**KIRKLEES METROPOLITAN COUNCIL
INVESTMENT & REGENERATION SERVICE**

DELEGATED DECISION TO DETERMINE PLANNING APPLICATIONS

Reference No:	2022/62/93221/W
Site Address:	48, Foster Avenue, Crosland Moor, Huddersfield, HD4 5LN
Description:	Erection of two storey extension to side
Recommending Officer:	Tom Hunt

DECISION – Conditional Full Permission

Project
Erection of Two Storey Side Extension and Internal
Alterations at 48 Foster Avenue, Crosland Moor,
Huddersfield, HD4 5LN.
Client
Mr & Mrs D Wilkinson
Drawing Title/Issue
Proposed Plans and Elevations
scale date sheet size dwg. no.
1:100 08/2022 A2 22/821/04c

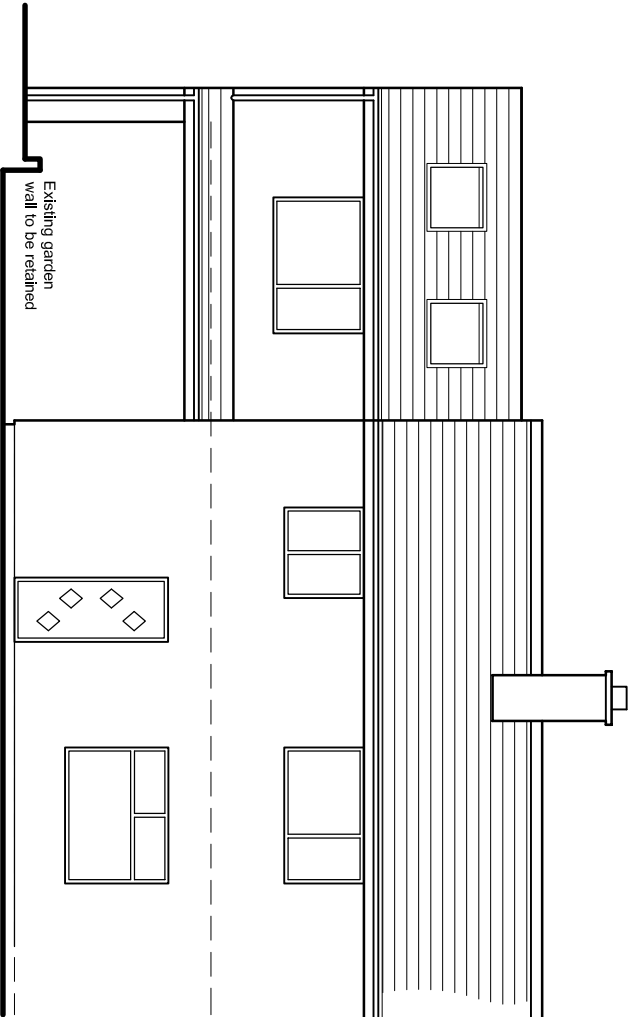
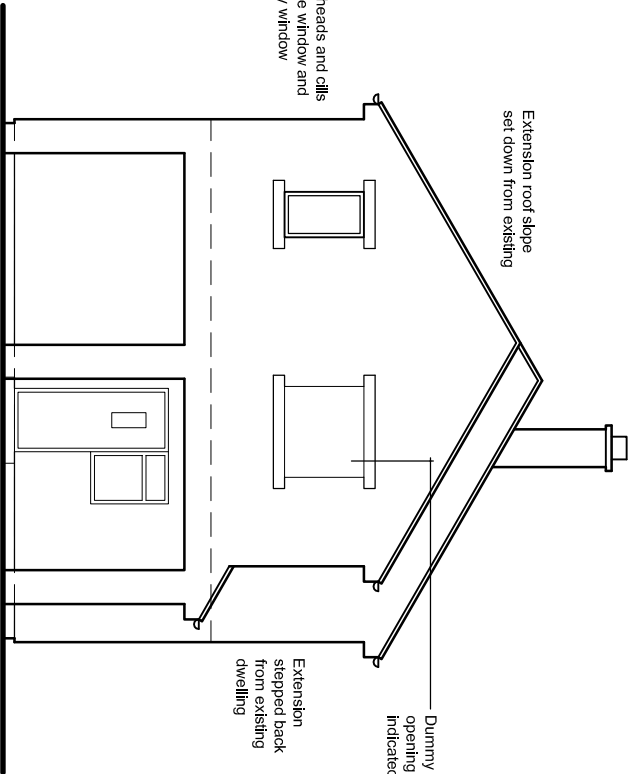
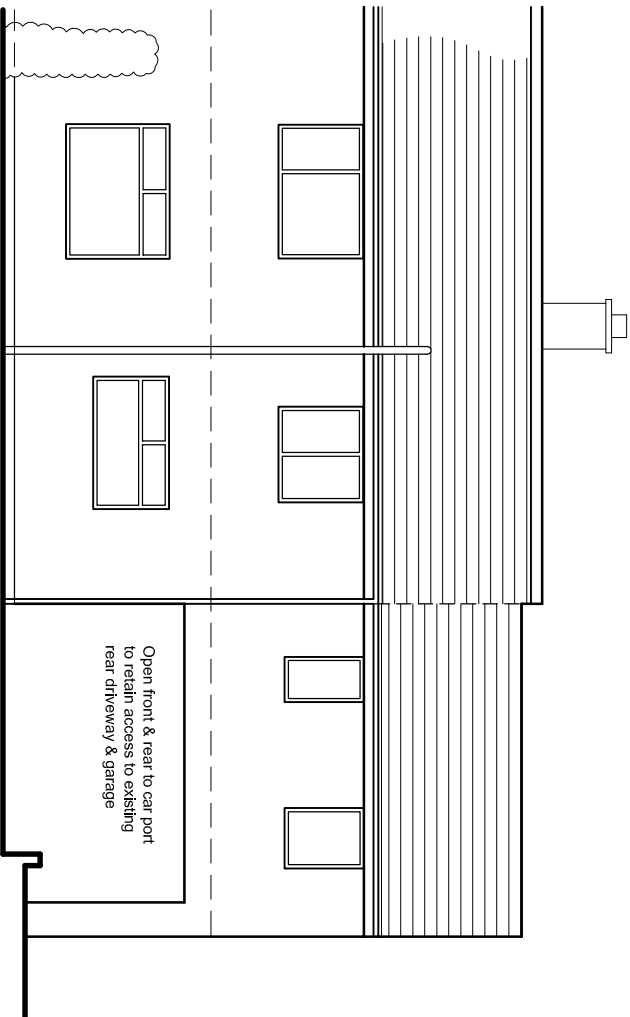
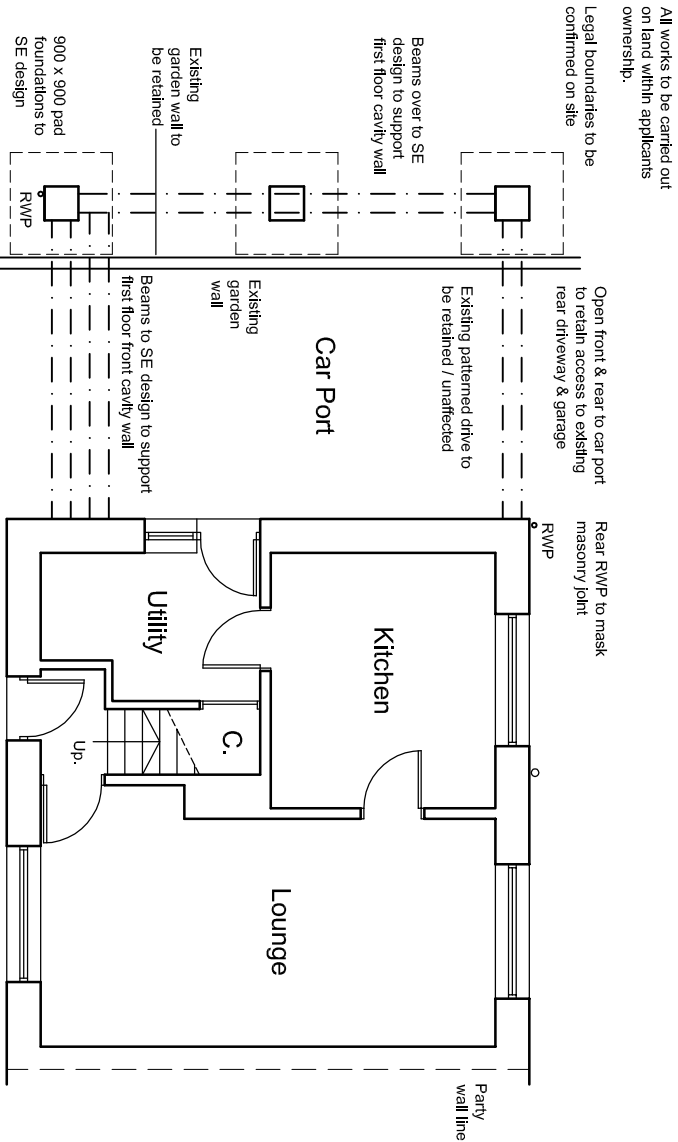
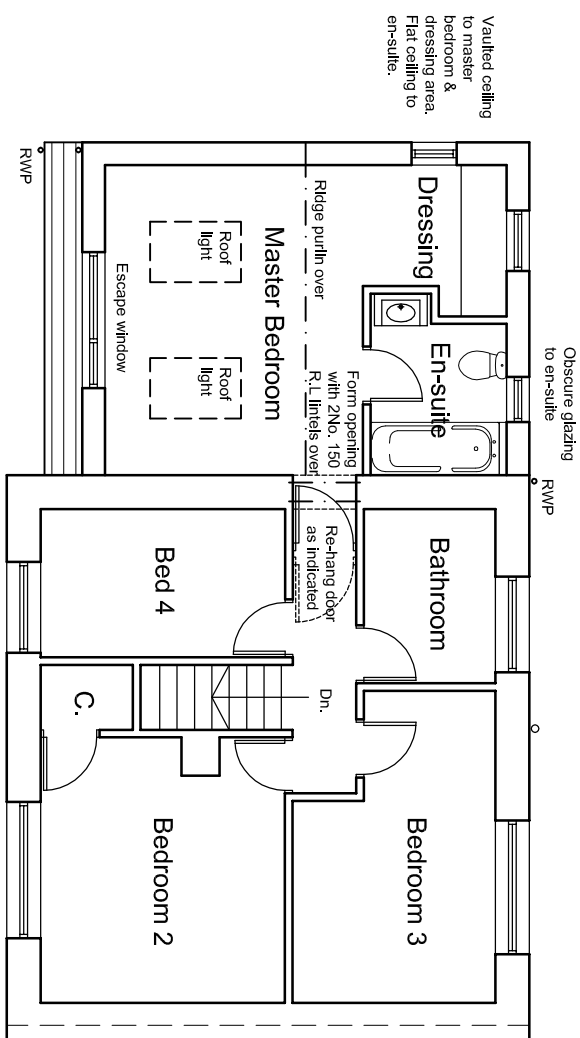
The case officer considered the application on review and sought an amended plan to increase the active frontage to the side elevation and parking and bins arrangements to be demonstrated within plans.

A dummy window and a small window were added to the side elevation at first floor in amended plans. There is a separation distance of ~23m facing a property gap between the opposite properties from the window and this would only have oblique views causing no additional impact to overlooking or loss of privacy, therefore amended plans were not re-advertised.

be front, side and rear with two skylights to the front roof elevation. A dummy window would be inserted to the side elevation with the adjacent window.

scale 1:500 date 08/2022 sheet size A4 dwg. no. 22/821/05a

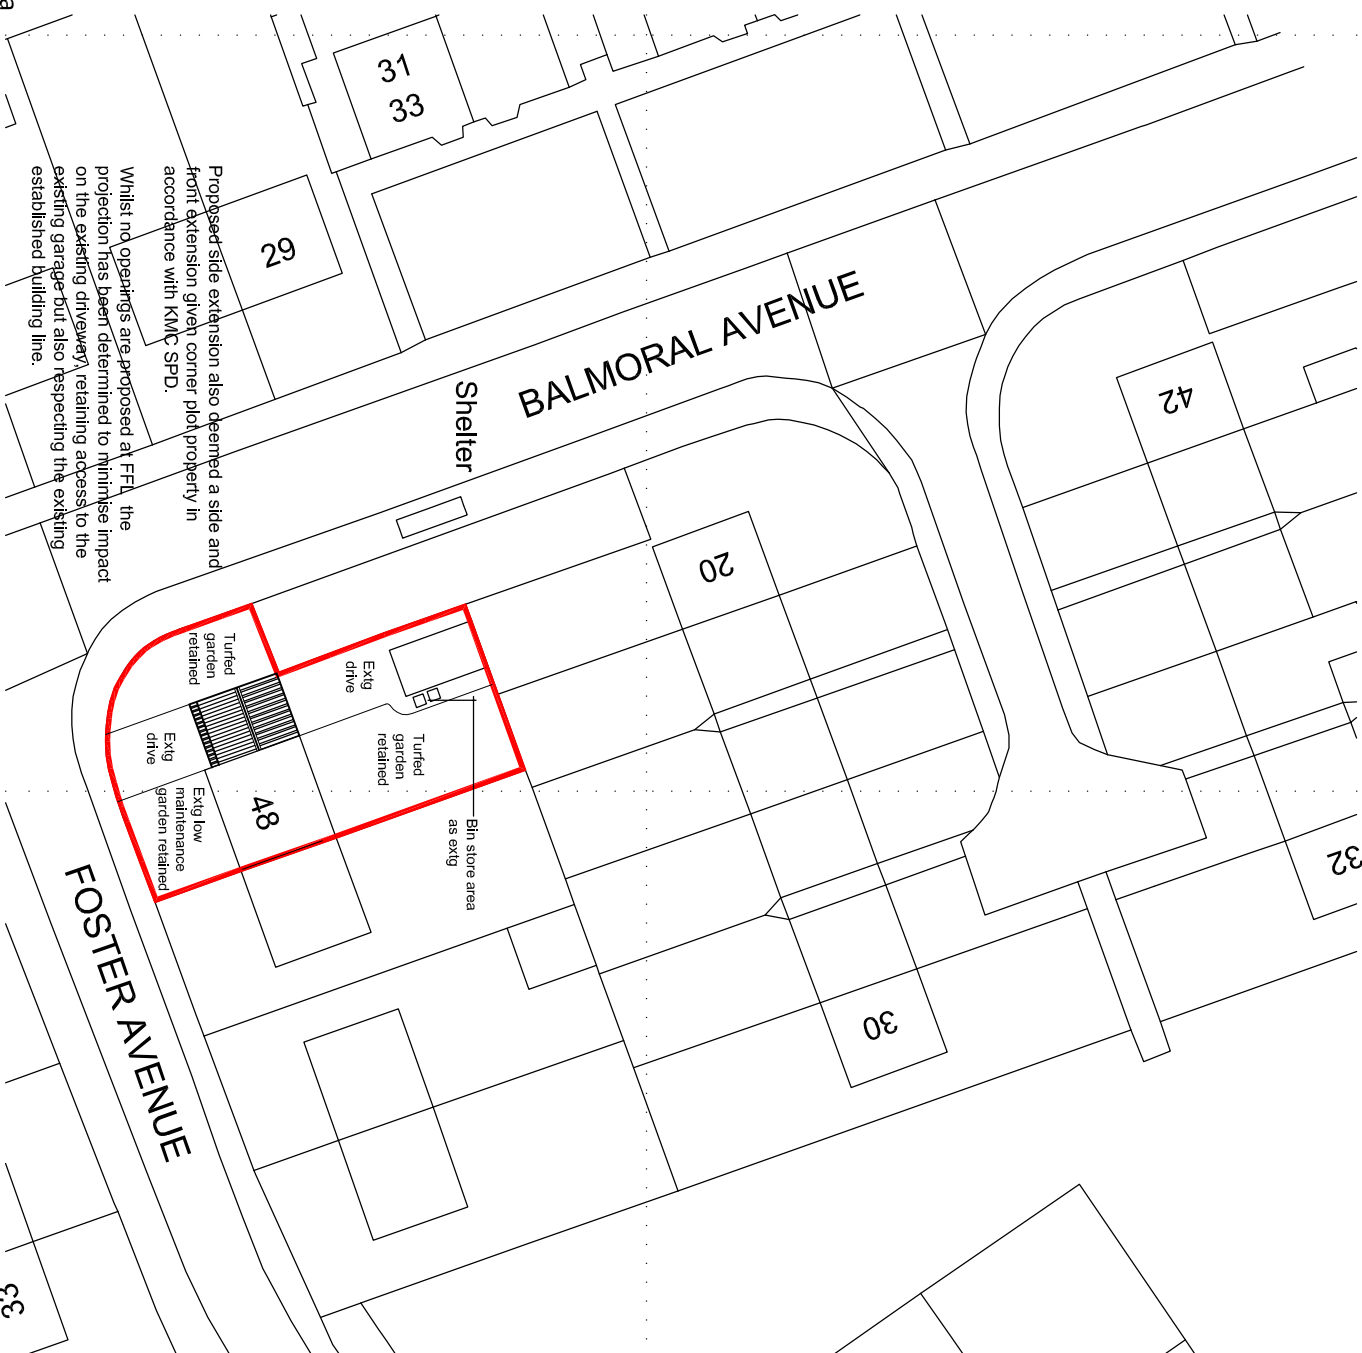
The Highways Development Officer was informally consulted and advised a parking layout should be supplied to ensure sufficient parking for its intensified use.

The Officer requested a bin layout as well to demonstrate where the bins would be safely stored for visual and highway amenity. The site would use existing arrangements for bin storage to the rear of the side extension.

For a 4 plus bedroom dwelling, it should have three off street parking spaces and the agent demonstrated sufficient parking layout with the car port included to satisfy this requirement. The HDM Officer advised that the car port be conditioned as parking only and not be infilled to secure a parking space within its area. While there is a bus stop close by, the proposal would still be in an area far from a Local Centre and relatively isolated from facilities.

As such, on submission of the amended plans the proposed development would be able to support its intensified use without detrimental impact to highway safety and bin storage. This requires a condition to retain the car port as approved so as to provide sufficient parking spaces to serve the development in accordance with Policy LP22 of the Local Plan and Principle 15 of the SPD.
